Avonlie Solar (SSD 9031) Environmental Assessment Requirements

Environmental Assessment Requirements

Application Number	SSD 9031
Proposal	Avonlie Solar Farm which includes: <ul style="list-style-type: none">• the construction and operation of a photovoltaic generation facility with an estimated capacity of up to 200 MW; and• development of associated infrastructure, including a grid connection and battery storage facilities.
Location	Muntz Road, approximately 20 km southeast of Narrandera, within the Narrandera Shire local government area.
Applicant	Renewable Energy Systems (RES) Australia Pty Ltd
Date of Issue	9 February 2018
General Requirements	<p>The Environmental Impact Statement (EIS) for the development must comply with the requirements in Schedule 2 of the <i>Environmental Planning and Assessment Regulation 2000</i>.</p> <p>In particular, the EIS must include:</p> <ul style="list-style-type: none">• a stand-alone executive summary;• a full description of the development, including:<ul style="list-style-type: none">– details of construction, operation and decommissioning;– a site plan showing all infrastructure and facilities (including any infrastructure that would be req

Figure 7-1 Ecological condition of the proposal area

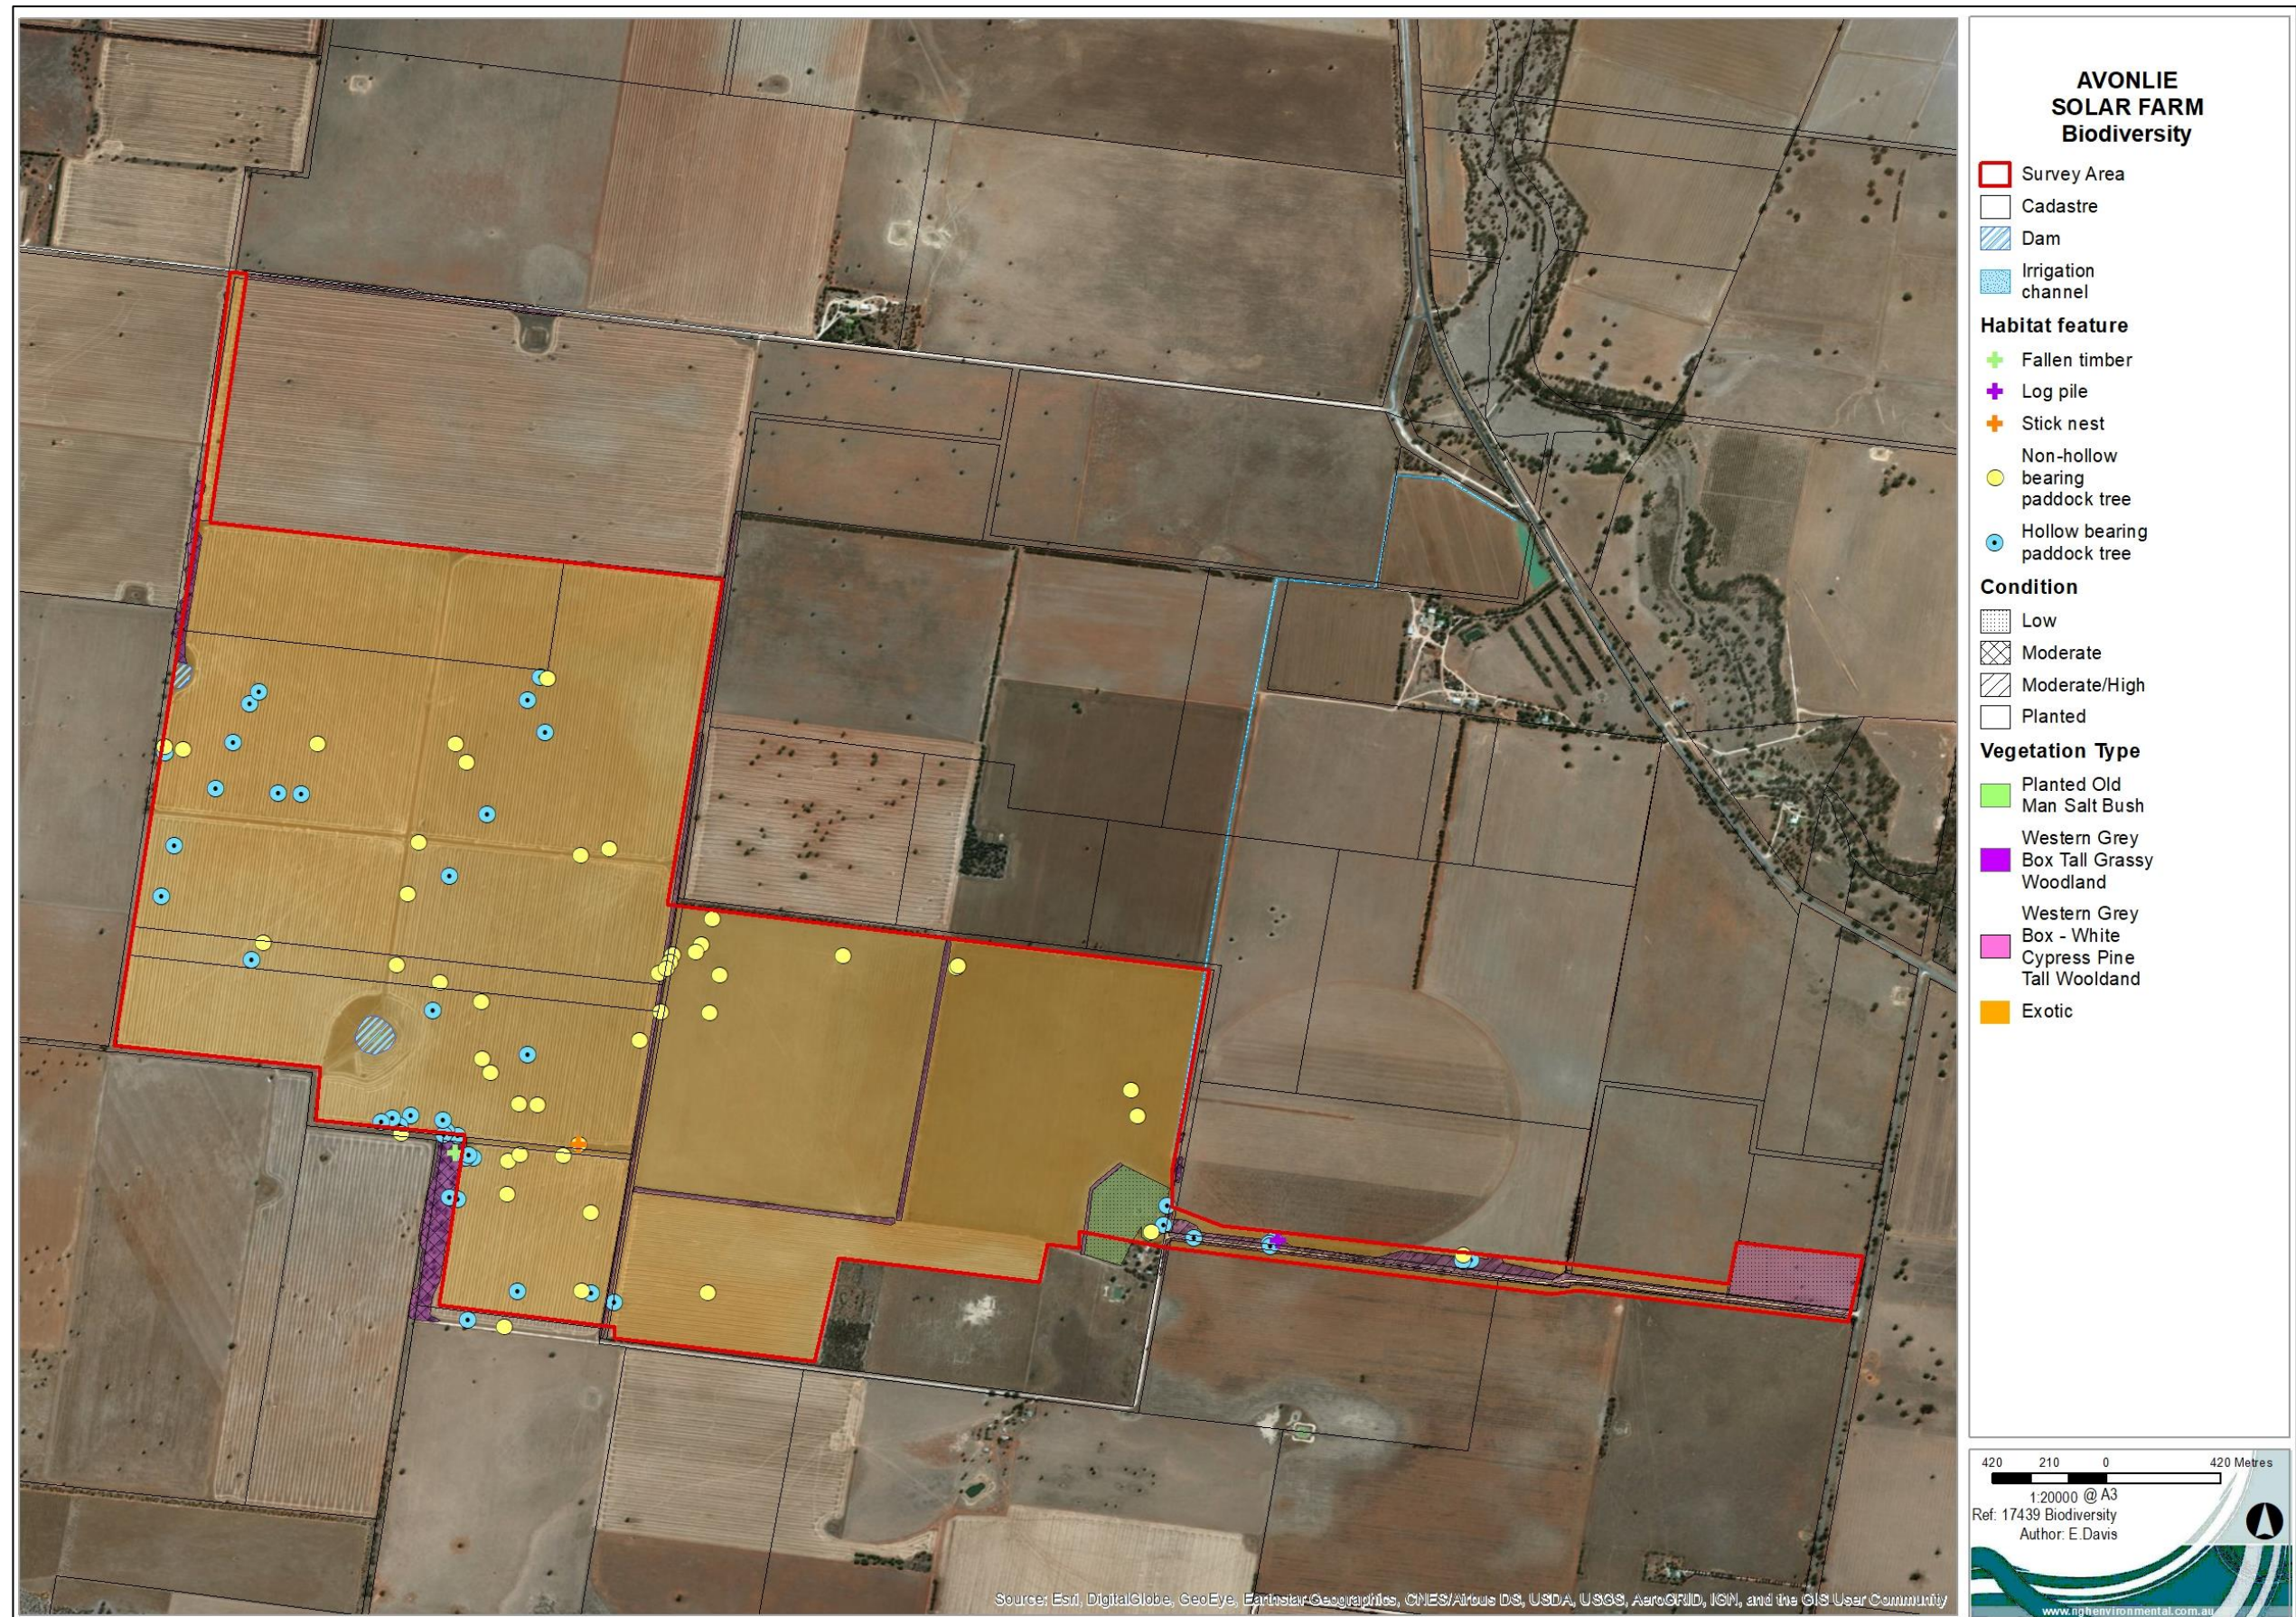
It is unclear in the PEA whether the 'Western Grey Box tall grassy woodland' on the western boundary in Figure 7-1 is planned to be completely cleared. We would like to see this avoided and assume based on location and configuration of the solar farm that this would be possible.
